Re: Addison Galaxy FBO Civil Plan Review

Development: Galaxy FBO  
Town Project #: 19-09D  
Plan Review: 1<sup>st</sup> Civil Submittal

Summary of Engineering Review Comments

SHEET NUMBER
C09.01

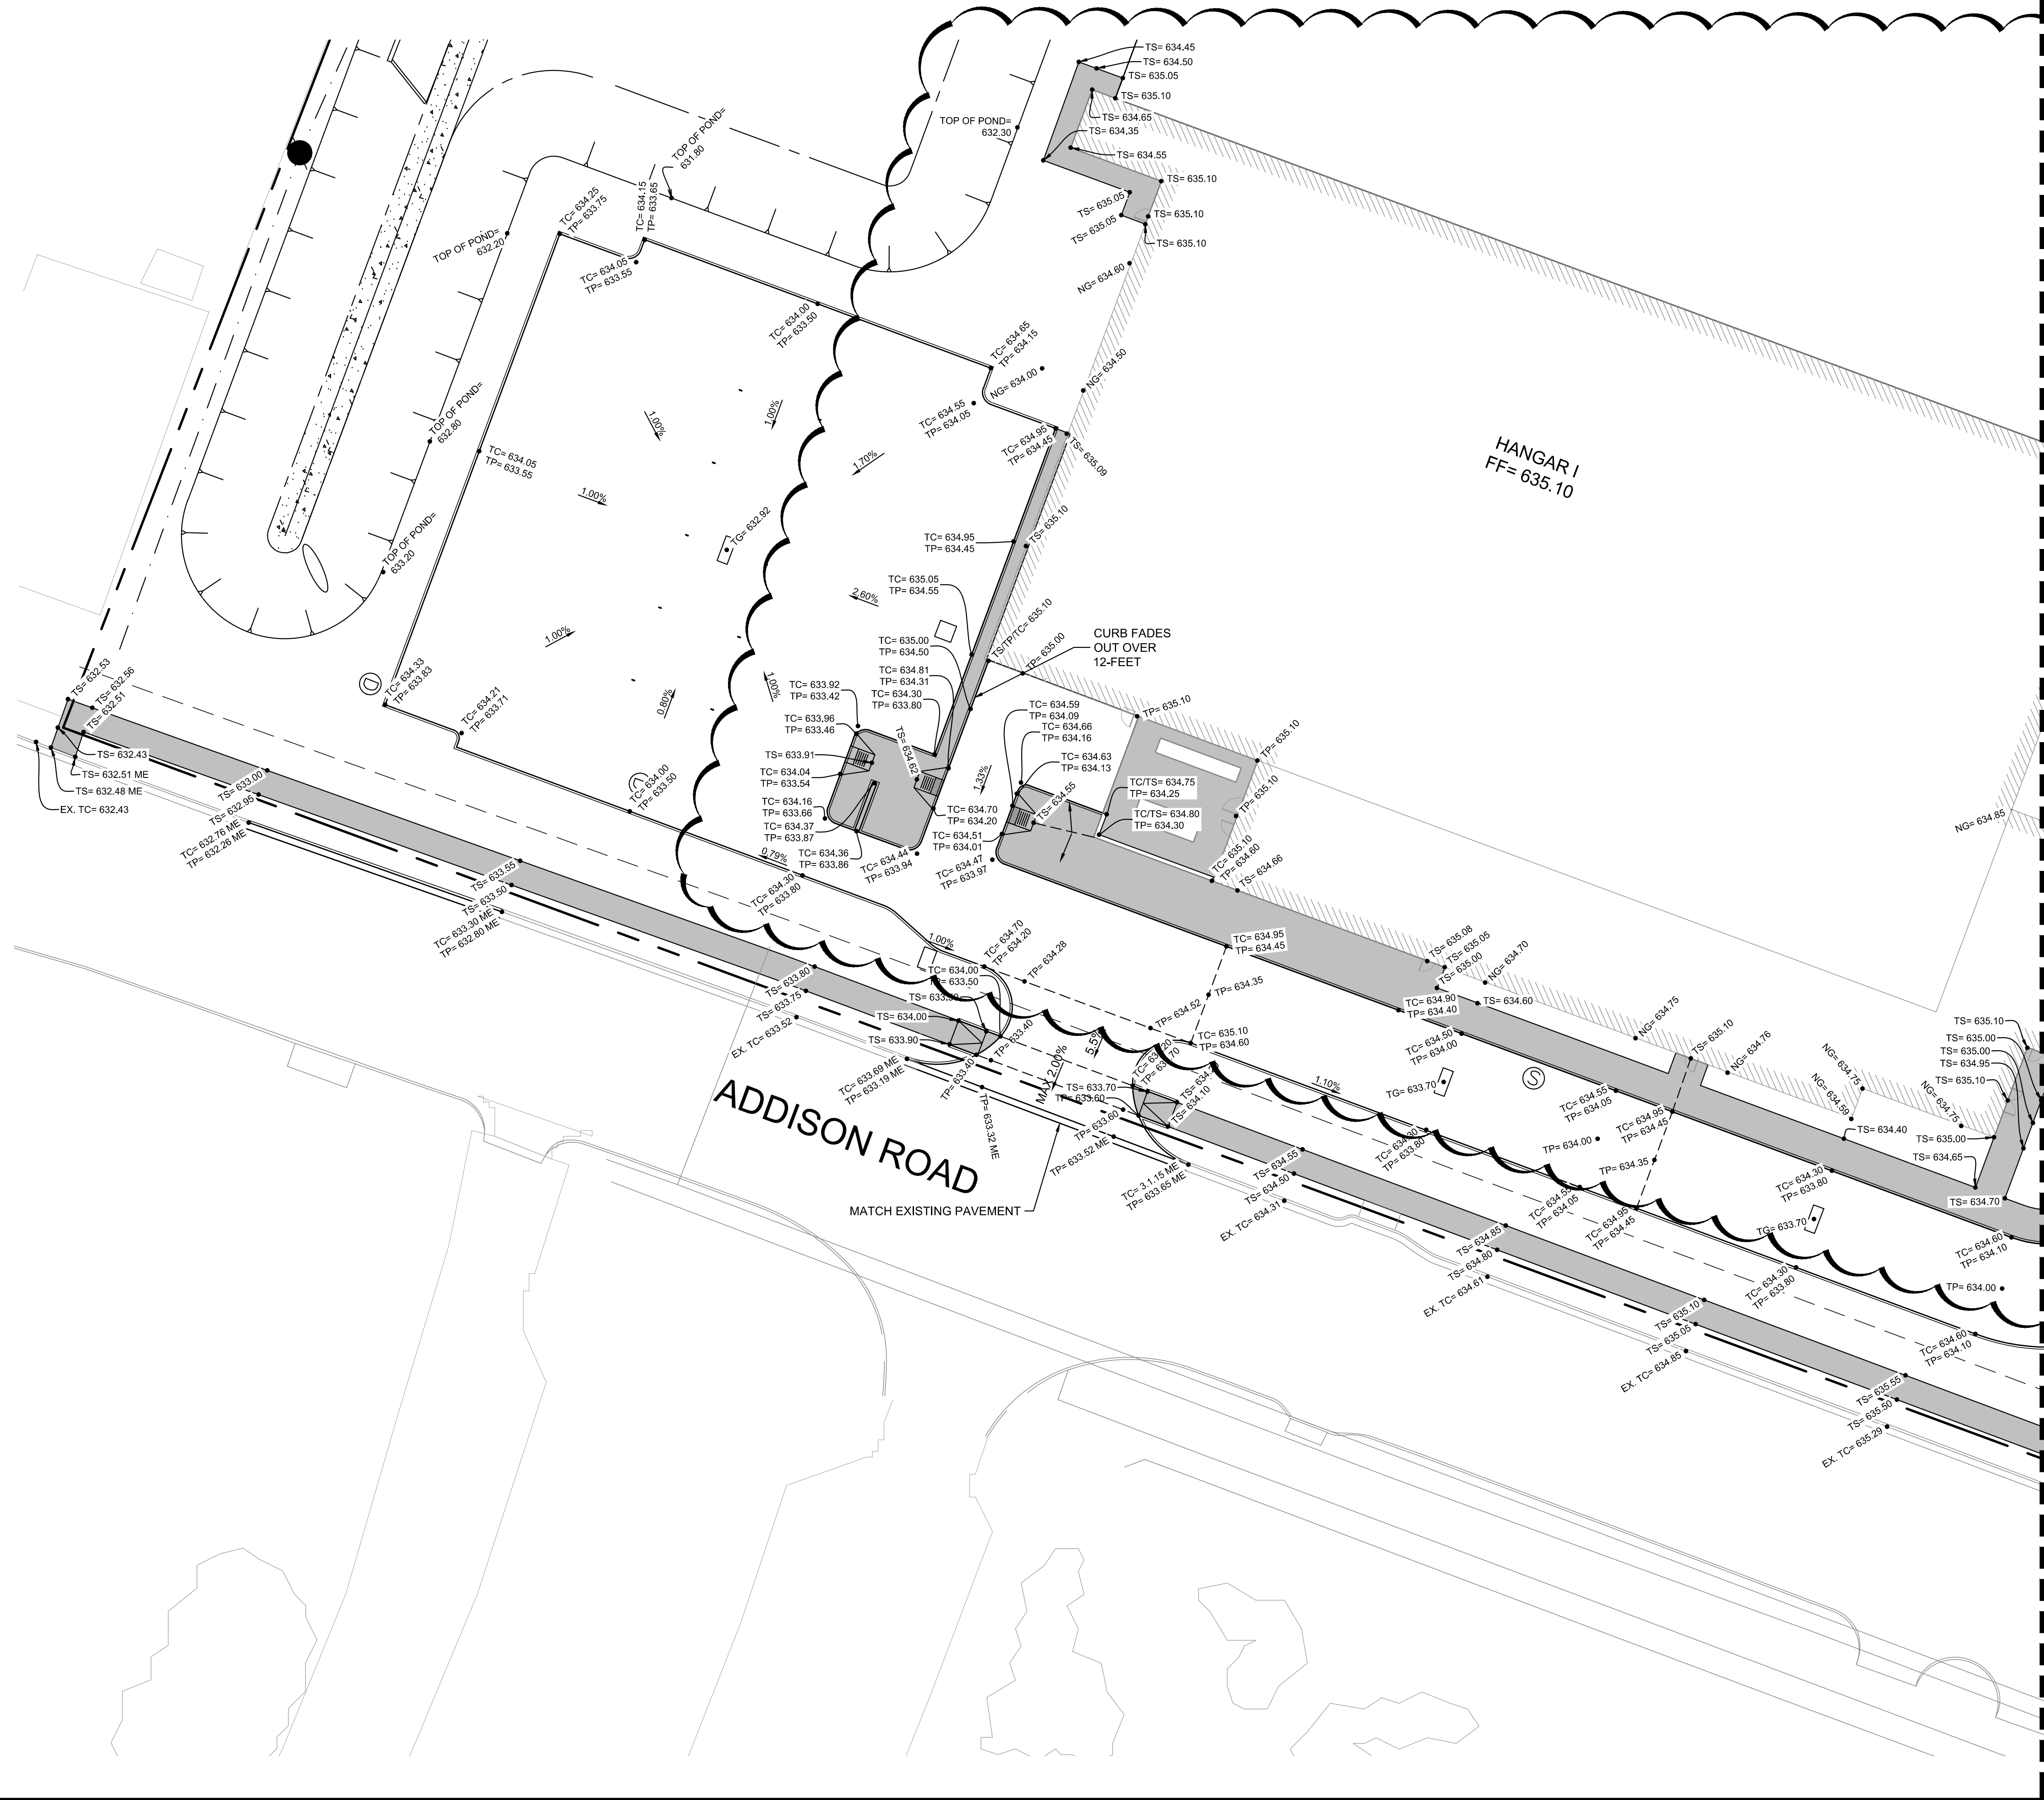
GRADING	Add elevations at existing pvmt connections to elevation point sheets		
GRADING	Please move the grading plan sheets to immediate follow the elevation point sheets.		
C09.01	Provide grades for curb replacement		
C09.01	BFR's should have return curbs, not wings.		
C09.01	Add TOC & back of sidewalk grades w/ max 2% grade callouts for parkway.		
C09.02	If the darker crosshatched area is pedestrian, need spot grades.		
C10.00	Need pre-development & post-development DAM's.		
C10.00 & 12.07	Seems that at least some of the fuel farm drainage is captured by or flows through your site. Coordinate with Dave Wilde for records & show how this is being handled.		
C10.00	Legend shows DA boundaries are existing, but they match the proposed layout.		
C10.01	City of Houston drainage manual???		
C10.01	Why are you using different intensities for the western & eastern collection lines?		
C10.01	Both storm drain lines outfall at the detention pond, so should match beginning HGL's, which should match the 100-yr WSL of the pond.

SHEET NUMBER
C17.04

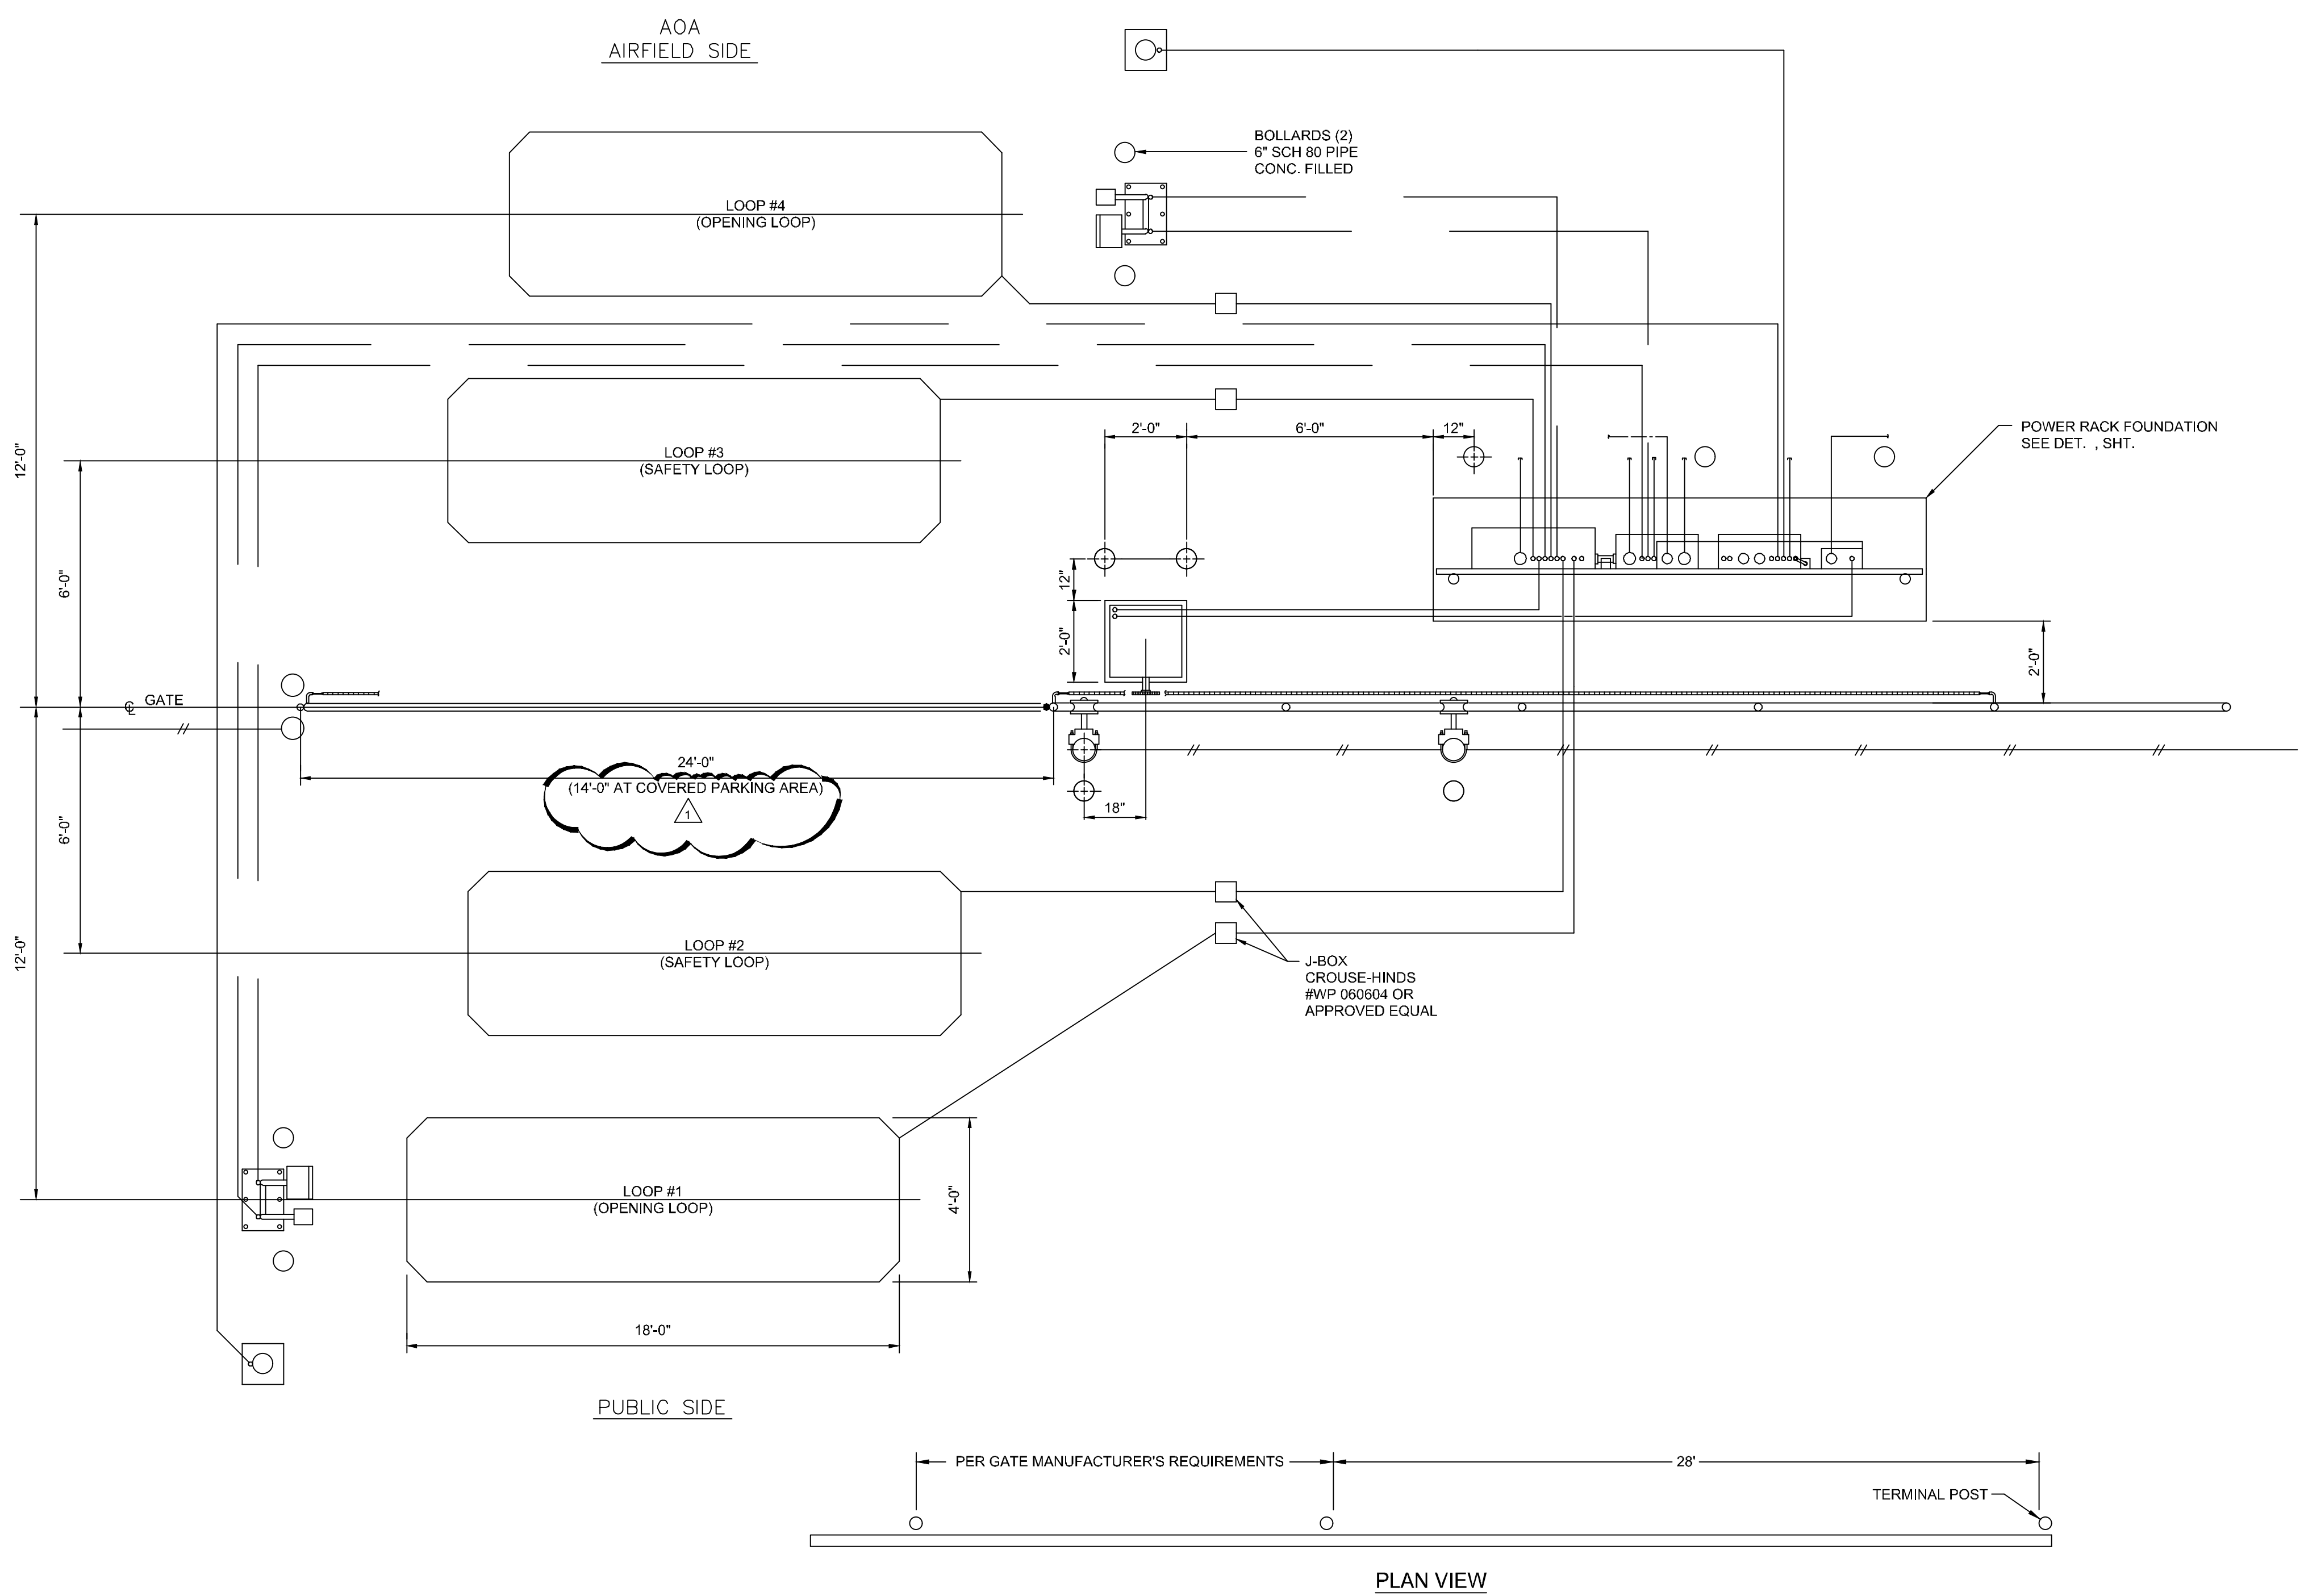
FENCING	Coordinate Knox locations w/ Fire Marshall. Does there need to be Knox access on both sides of the gates that access public roads?		
C17.02	Will the proposed AOA gate to the fuel farm be swing or slide?		
C17.04	Detail for swing gate?

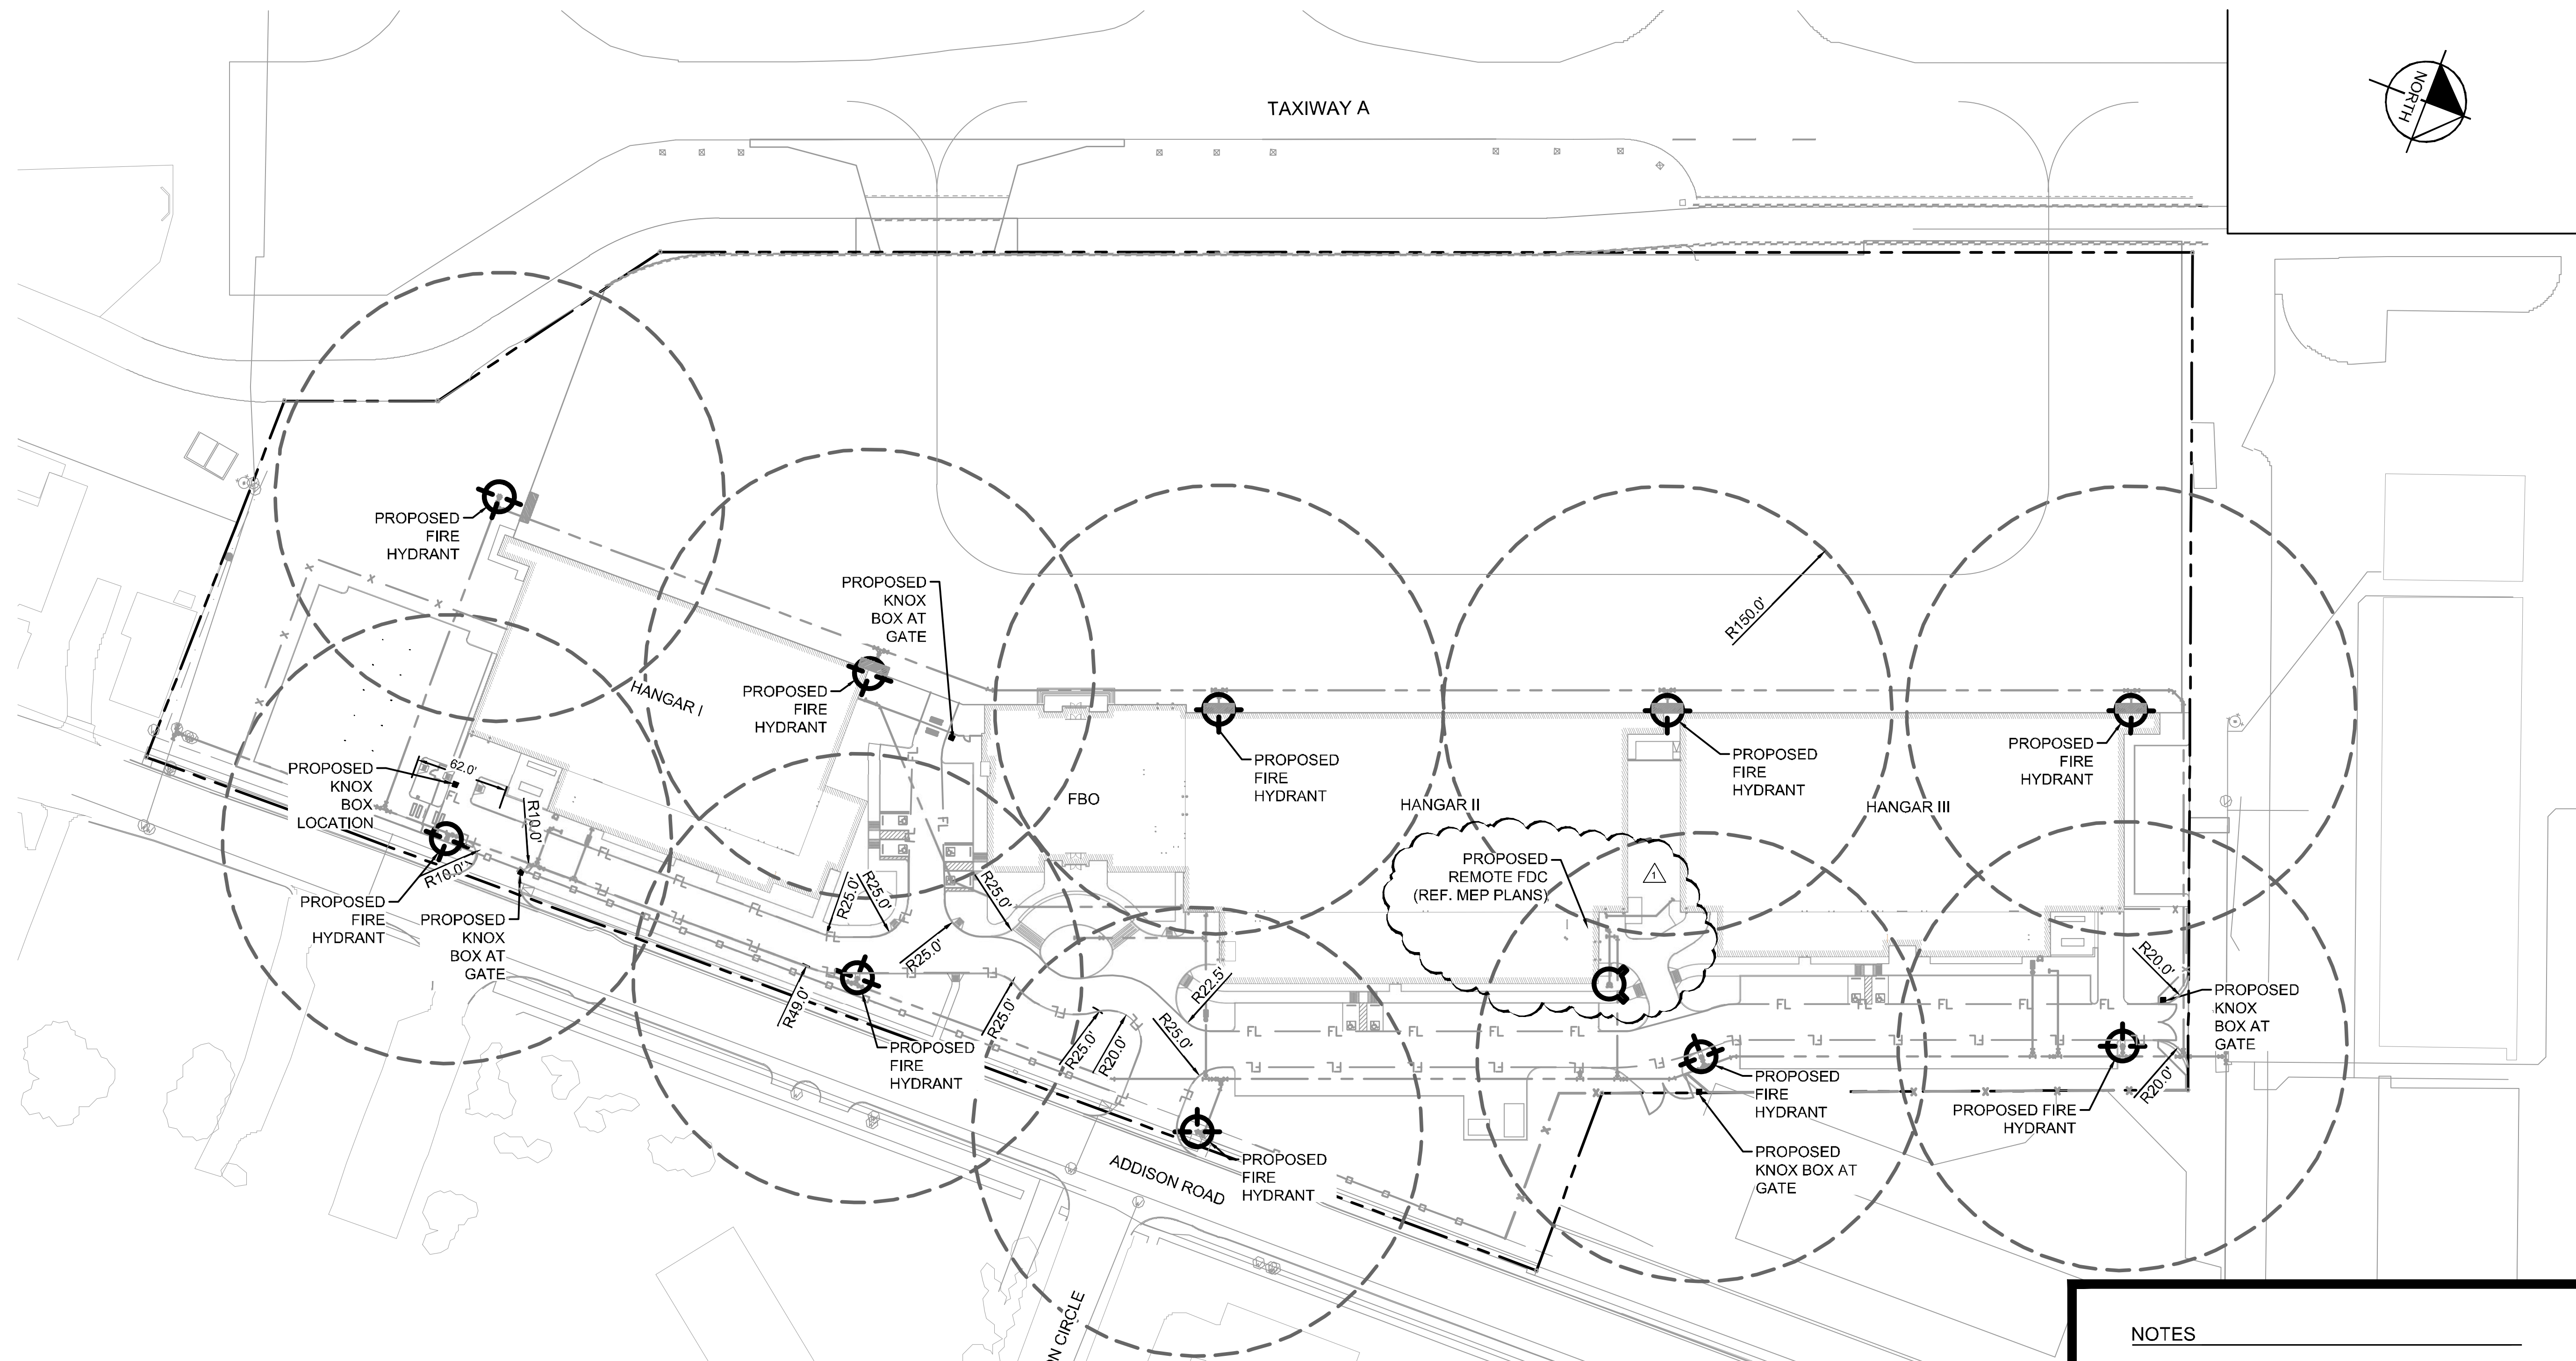
Page No.	Comments	Response (See Note)	Explanation
1 of 4	Update per zoning plan changes - should reflect approved zoning plan (have not received resubmittal for review & approval).		
1 of 4 & C05.03	What is the paved area north of Hangar III and south of George Haddaway? Parking? Loading? Storage?		
C00.10	Hydrants must maintain minimum 3' (prefer 6') clear from bldg foundation for future maintenance/service.		
C01.00 & 03.01	Extend project limits to encompass ALL paving/grading/drainage/utility work.		
C01.01	Does the existing double 24" RCP have SET's or headwalls?		
C01.02 & 01.03	Check your viewports - plan view doesn't line up with labeling arrows.		
C02.01 & 02.02	Include CI protection on Addison Rd inlets.		
C02.03	Revise sheet number		
C02.03	Use TOA standard details where applicable.		
C03.01	Note to remove existing landscaping as applicable.		
C03.01 & 11.02	Where is the OH being relocated? Show.
